# Permit Inspections Harnett County

Permit Number: **SFD2306-0119**

Description: **40x39 sfd 5 beds 3 baths**

Site Address: **171 BLUE ASPEN DR**

Second Floor Layout

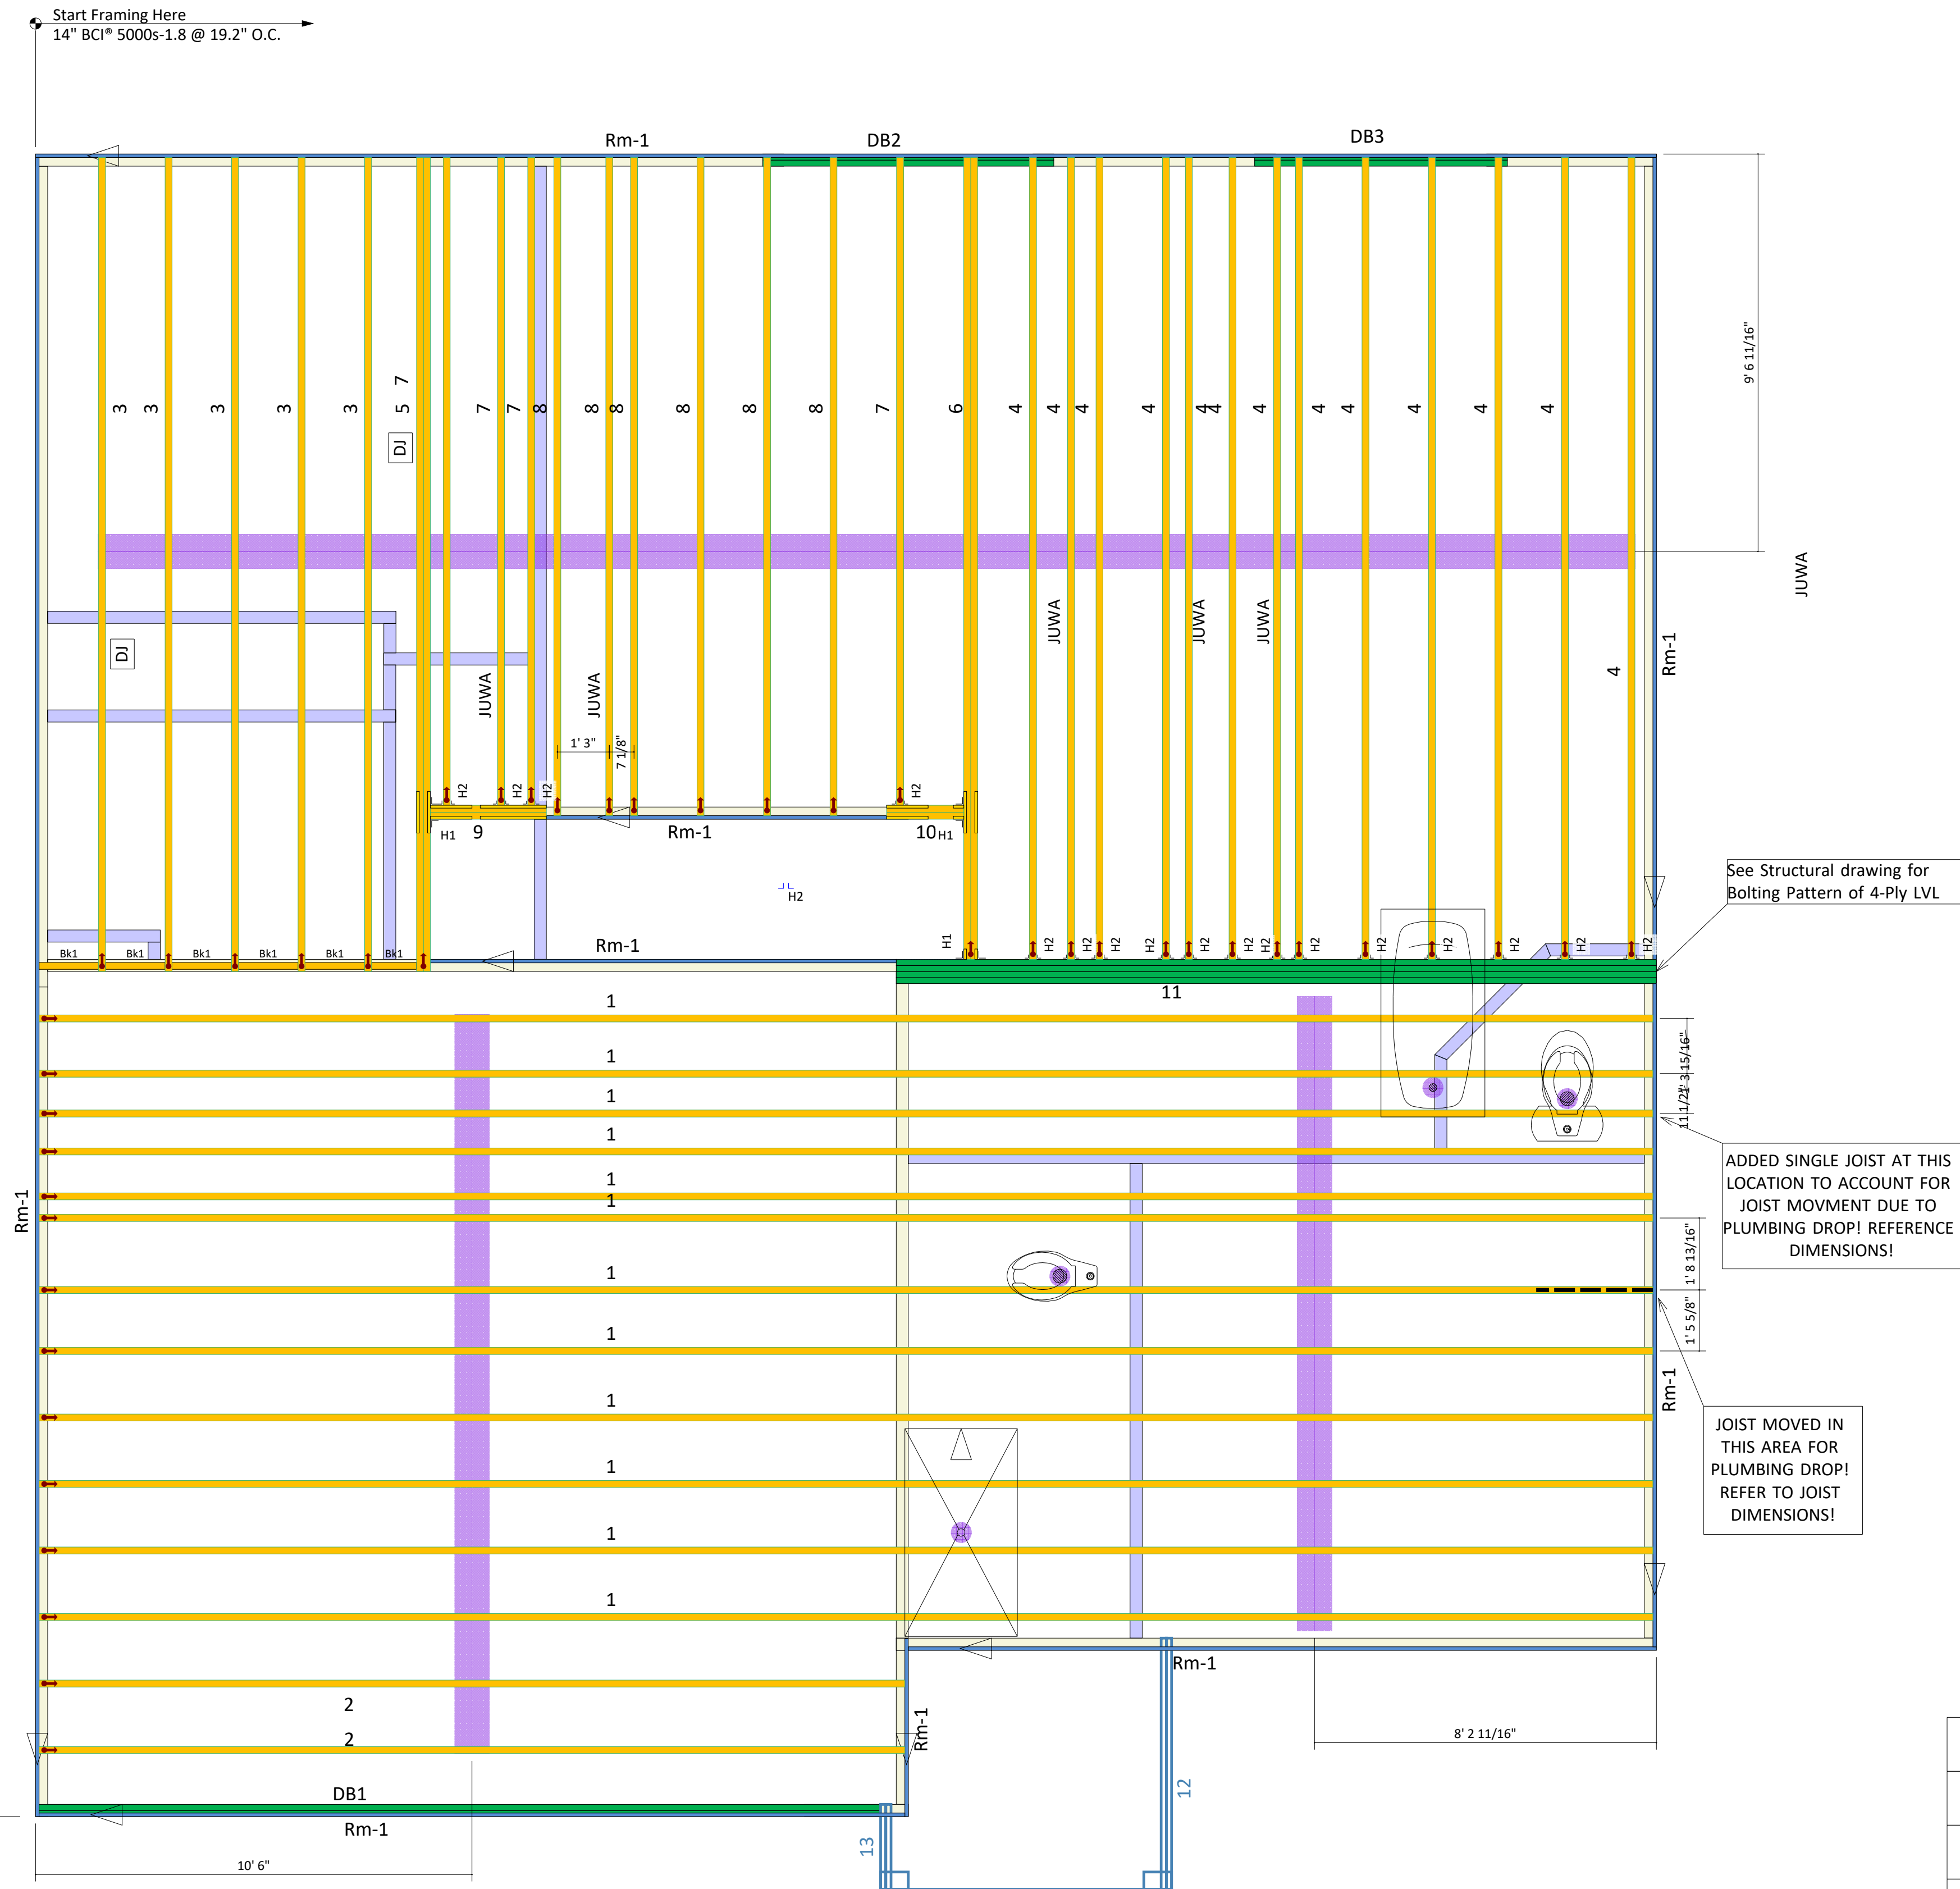
1. Repair air barrier in chase by the downstairs tub  
 2. Build a chase around 3 inch stack in the pantry  
 3. Missing nails in hangers on 4 ply lvl4. Need a nail plate at the top plate at the chase in the left rear of the house upstairs  
 5. Missing nails in hanger at the stairs for double floor I beam  
 Ok to insulate
